## **AQUIND INTERCONNECTOR**

Applicant's Response to Deadline 5  
Submissions

Including Winchester City Council comments at  
Deadline 6 (25 January 2021)

**Table 2.6 - Winchester City Council**

TITLE: Application document reference 2.6  
Converter Station and Telecommunications  
Buildings Parameter Plans  
Combined Options  
Sheet 1 of 3

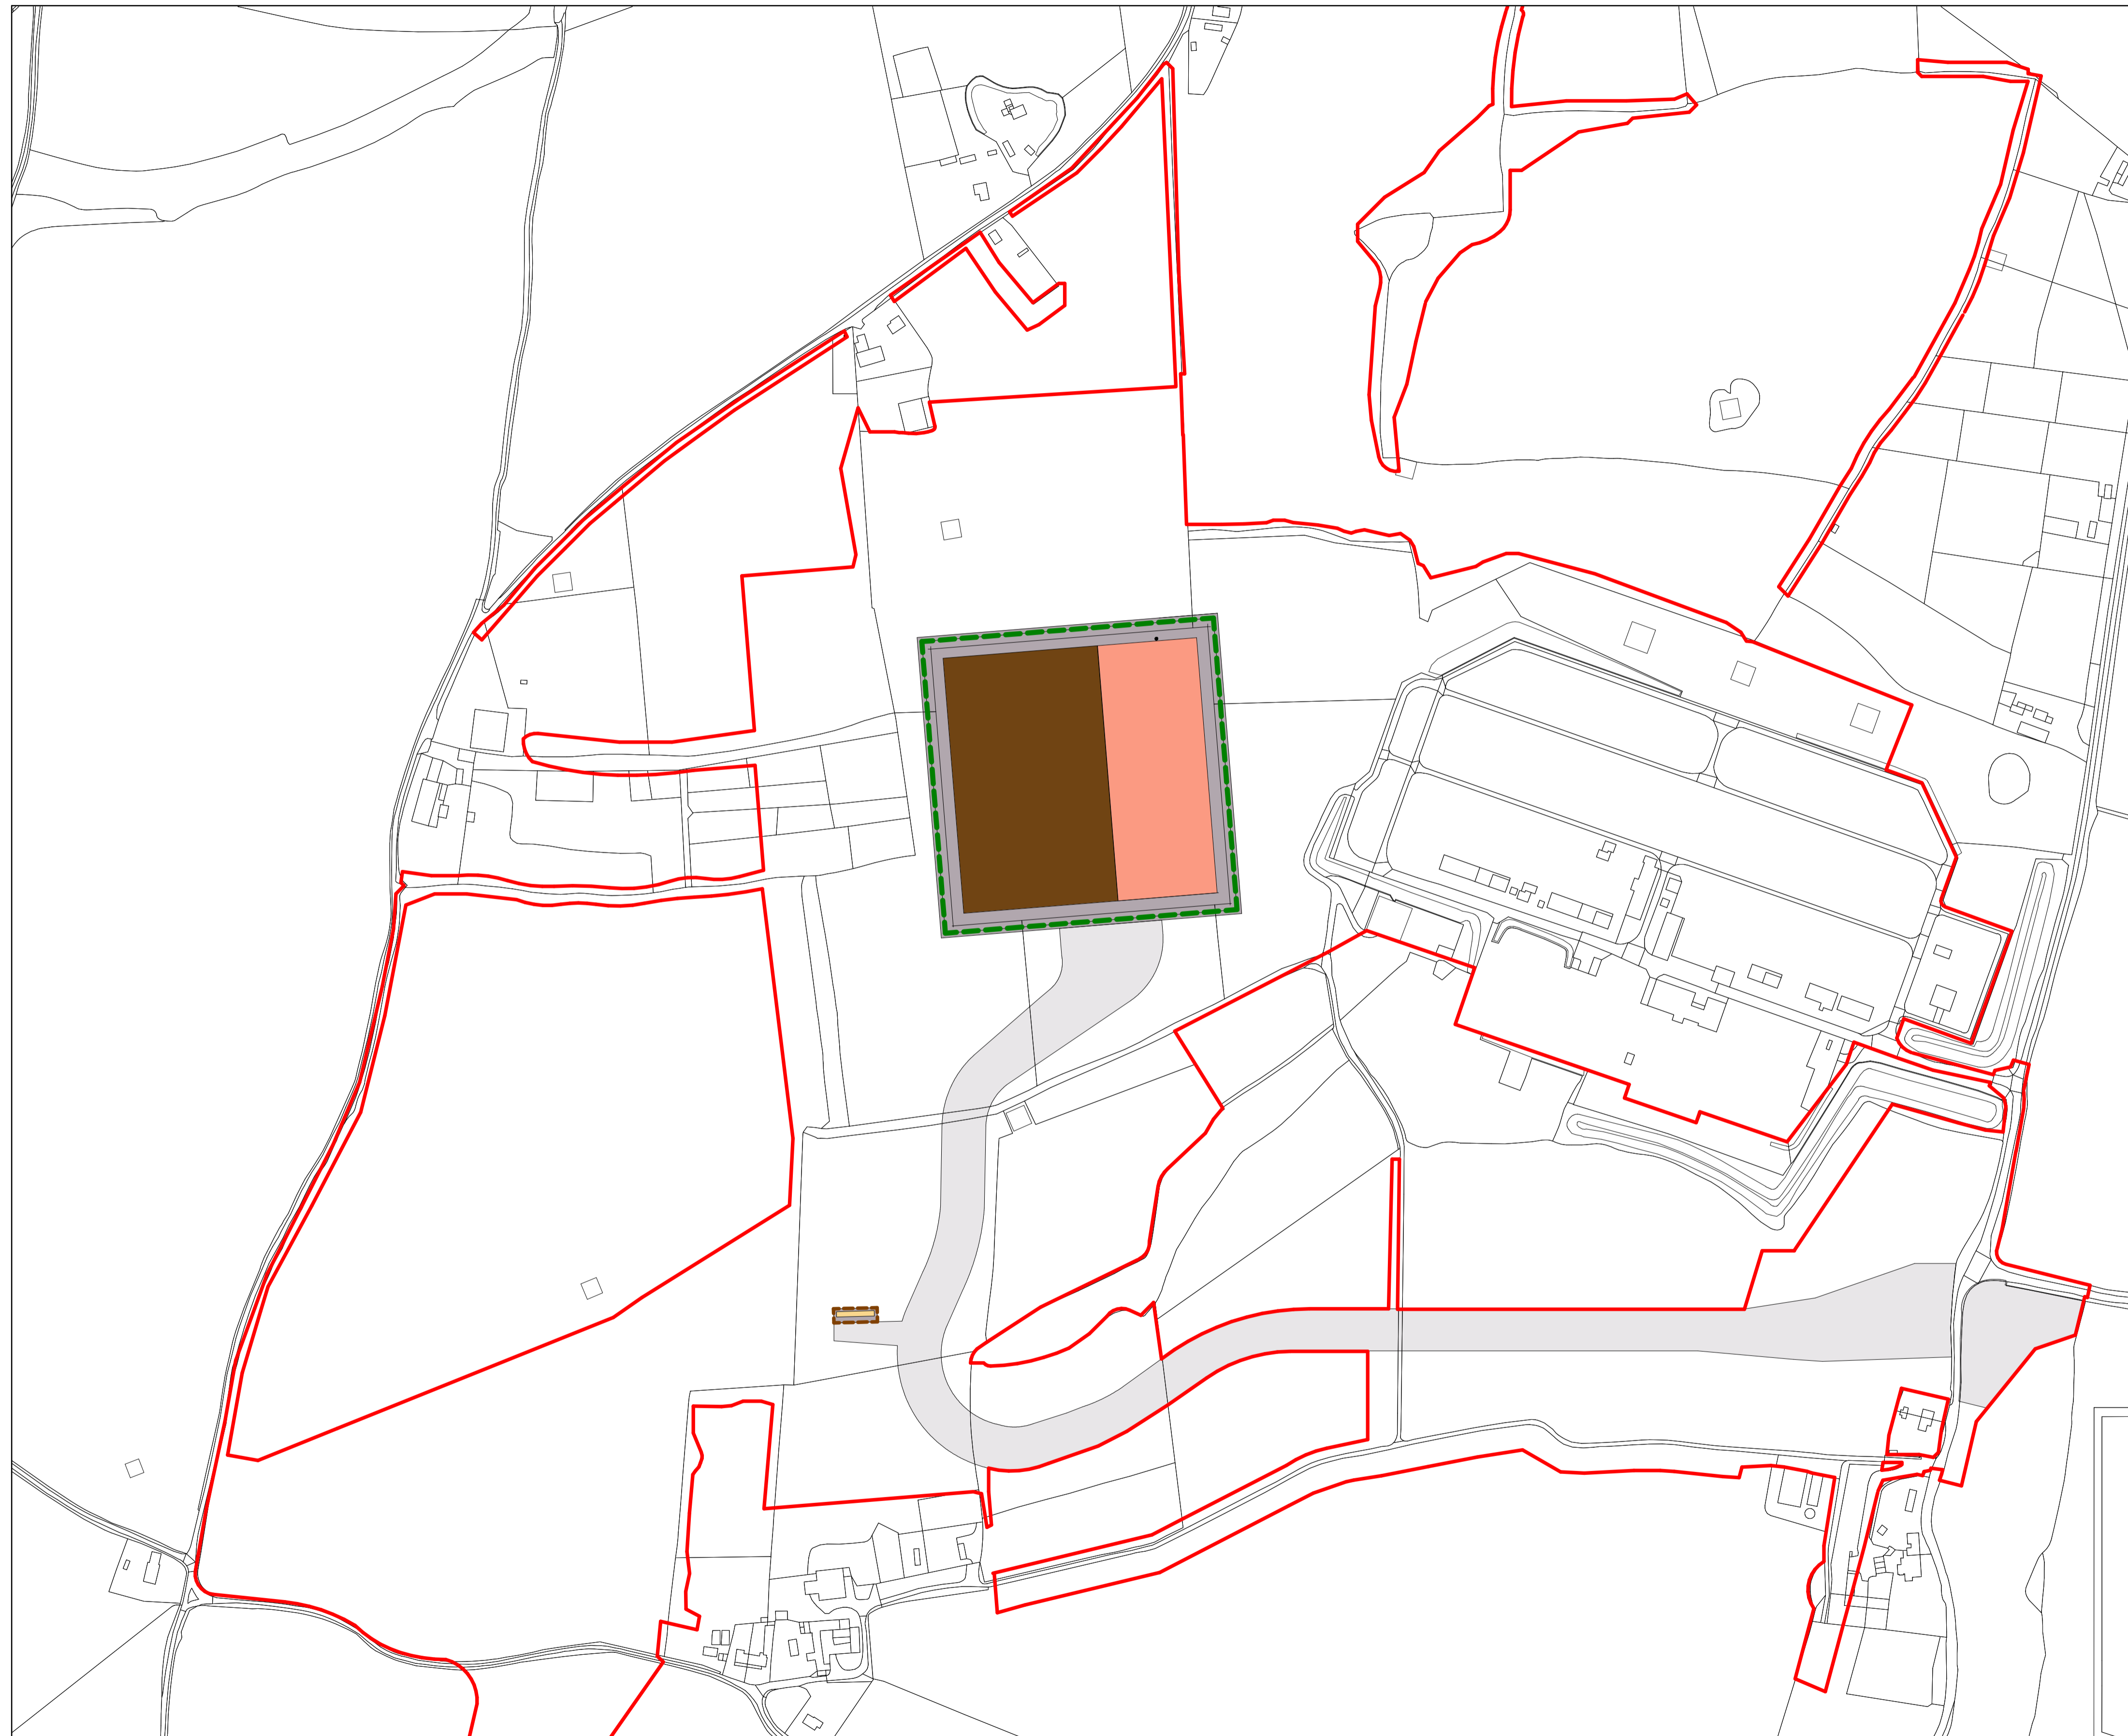
| Para No.   | Summary of Deadline 5 Submission   | Applicant's Response at Deadline 6  | Winchester City Council Comment  |
|--|--|---|--|
|  | <p>The Council notes the request to the applicant to clarify the situation regarding the Converter Station height. The Council wishes to take this opportunity to comment on that situation. It is understands that the height</p>   | <p>The Applicant seeks permission for buildings between 22m and 26m as stated in the draft DCO (REP5-008) and justified in the Design and Access Statement (REP1-031). These dimensions are based on advice which the Applicant has received from contractors</p>   | <p>See comments made to applicants D4 response.</p>  |

| Para No.                                  | Summary of Deadline 5 Submission  | Applicant's Response at Deadline 6   |   |
|---|---|--|---|
|   | <p>variation is to allow some flexibility in the design of the roof and its supporting structure. The final decision will rest with the contractor at the time the detailed design is finalised. The Council has sought clarification what weight will be given to minimising landscape impact in that decision.</p> <p>This is particularly pertinent if the lower building results in a higher capital outlay.</p>  | <p>experienced in constructing converter stations. As is explained in the Applicant's Transcript of Oral Submissions for Issue Specific Hearing 1 on Development Consent Order (REP5-058) in response to question 4.2 and in the Applicant's oral response in relation to the same, to ensure that no supplier is disadvantaged from offering their proposed technological solution the Applicant has sought to retain flexibility in respect of the height, and without this the Applicant would not be able to run a competitive tender process for the Converter Station taking into account the limited number of supplies of the bespoke equipment which comprises a converter station.</p> |   |
